DEVELOPMENT REVIEW BOARD
TRANSPORTATION DEVELOPMENT

DRB Project Number: 1002202
Winrock Center

SUBJECT: Sketch Plat

Planning Department- DRB Sketch Plat Review and Comment

INDIAN SCHOOL ROAD N.E.

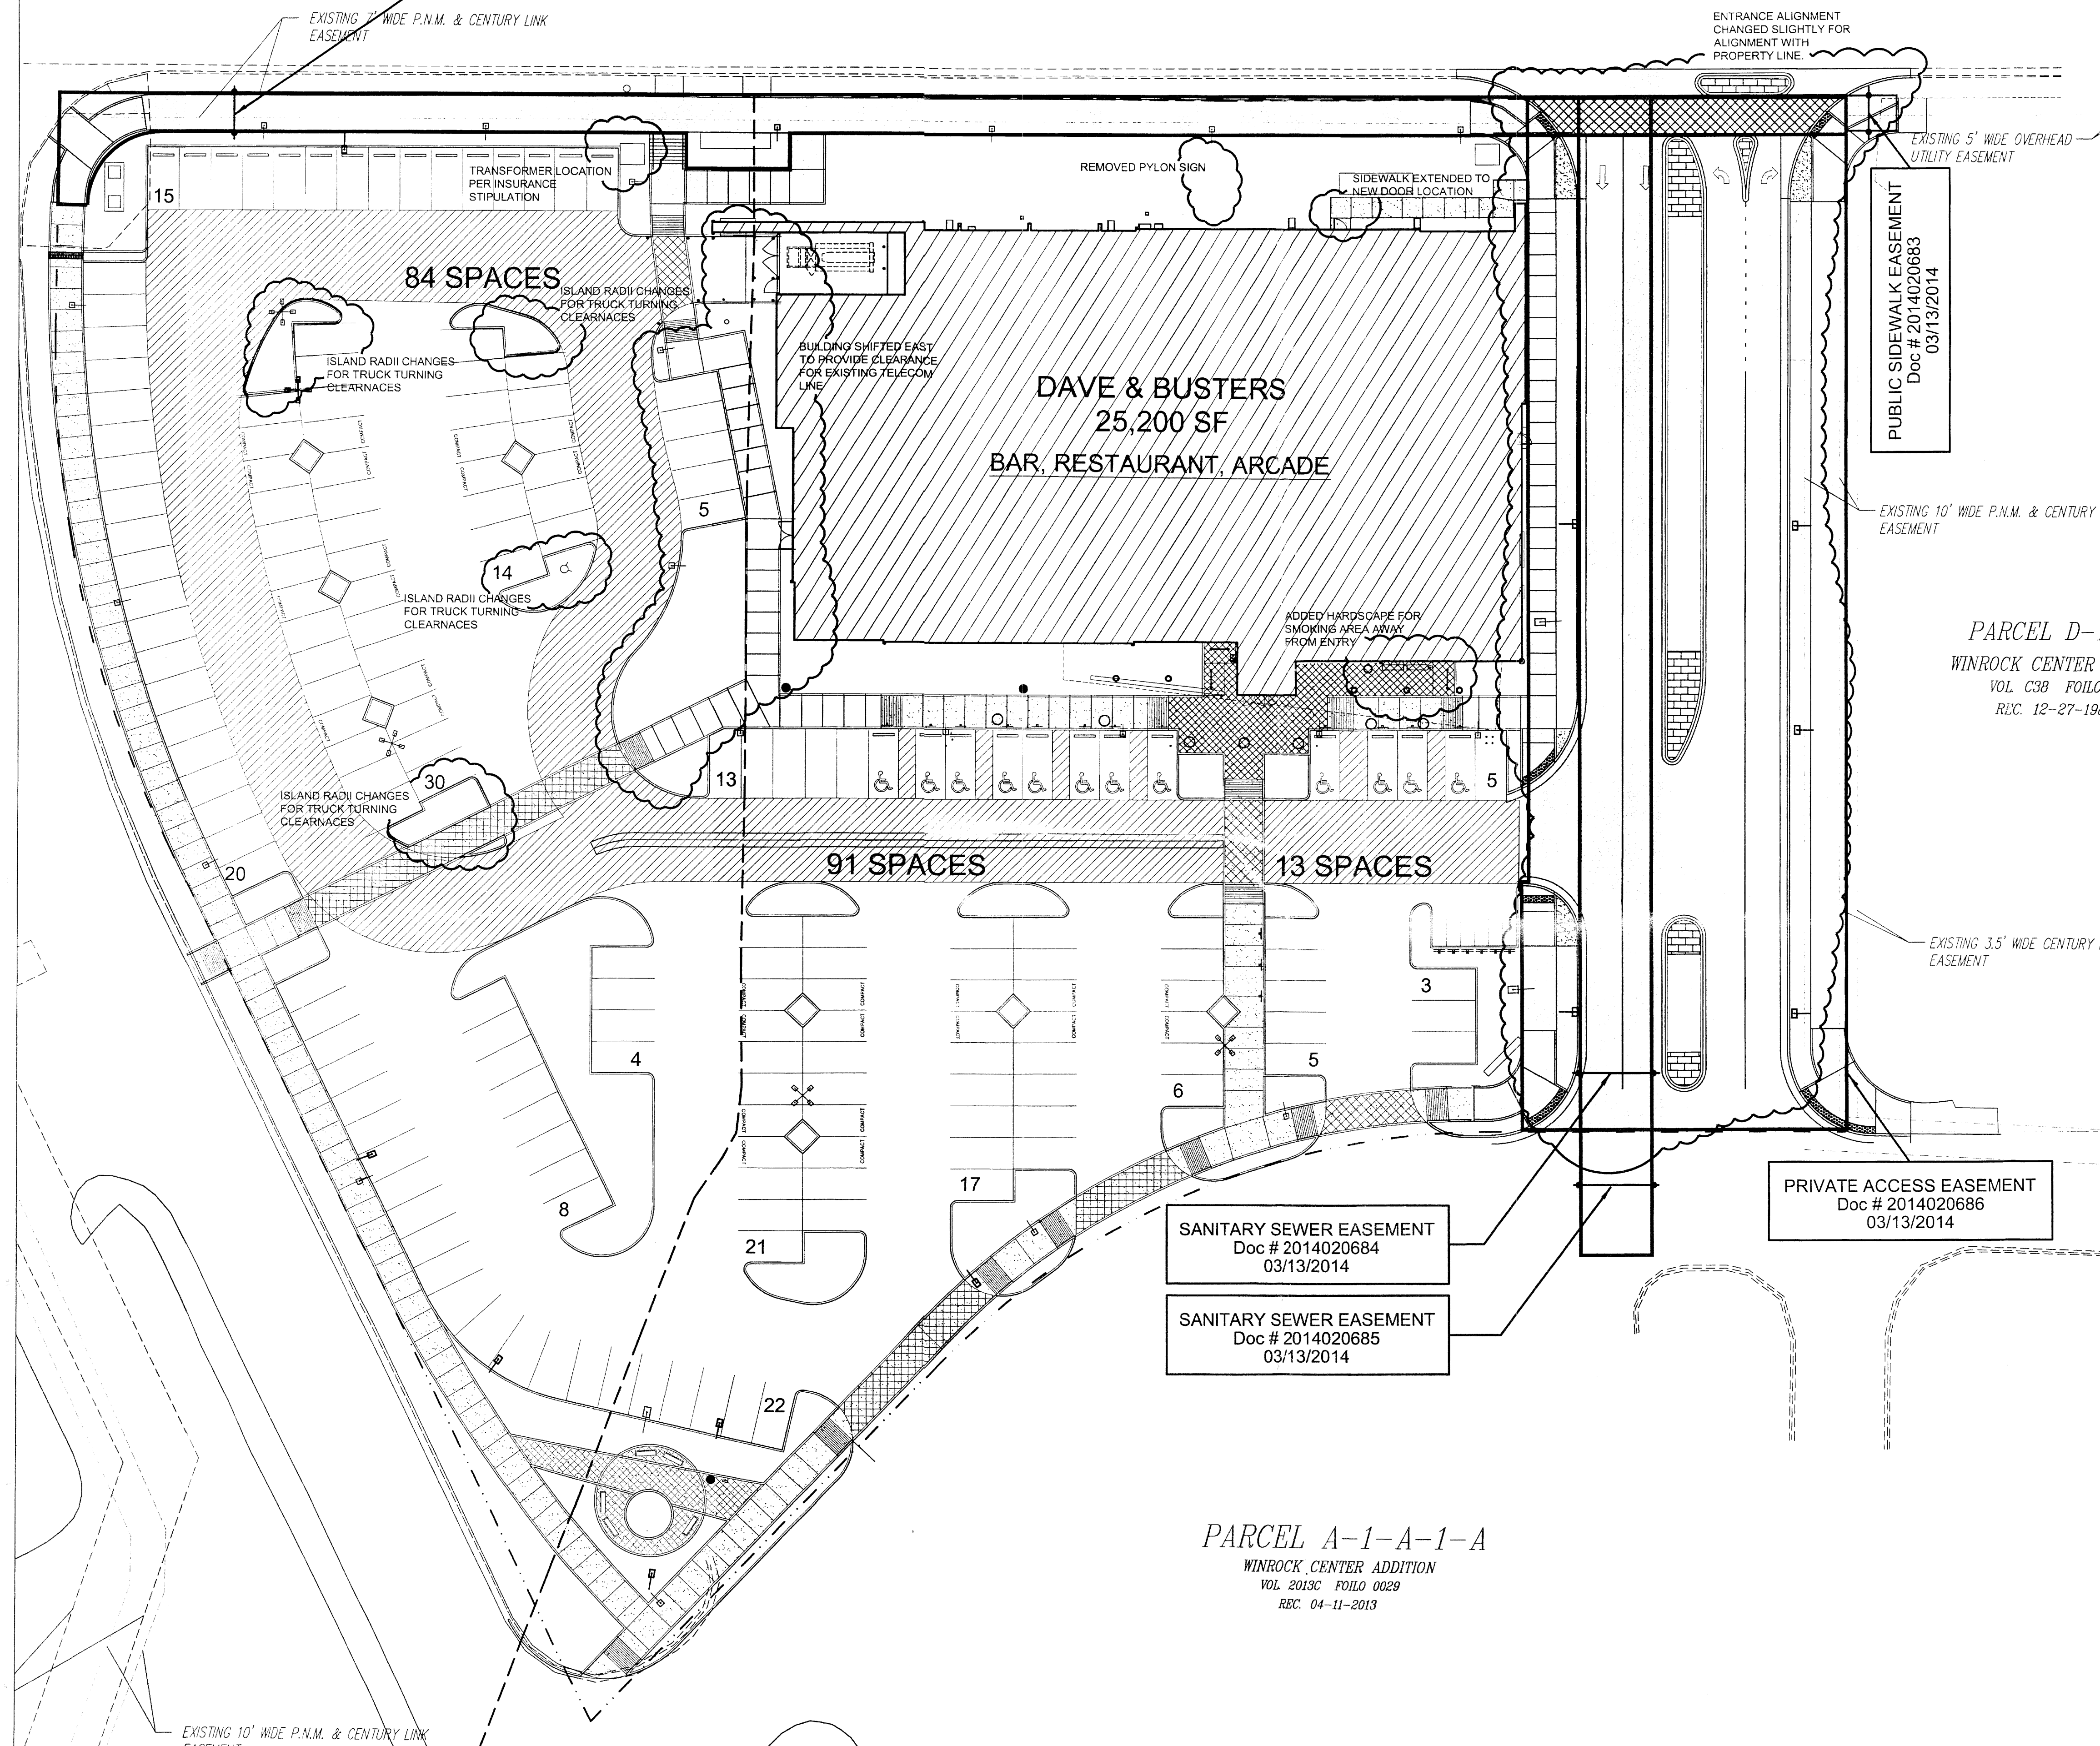
Line weights for existing parcels should be the same i.e. Tract A2, A1A1B, A1A2 and A3 boundary must have the same line weight as the boundary of A1A1A1A. Parcel A1A1A1A2 does not show up on AGIS as an existing parcel so it should not be labelled on this plat.

Access easements should be labelled public Access Easements. As shown now, Proposed Tract H is landlocked which is not allowed. Is there a public access easement from Louisiana into the site?

Are the proposed easements supposed to be R/W per TIDD?

Must add a signature block for Code Enforcement.

General: The parcel/tract numbers for the SPS and Plat should match.
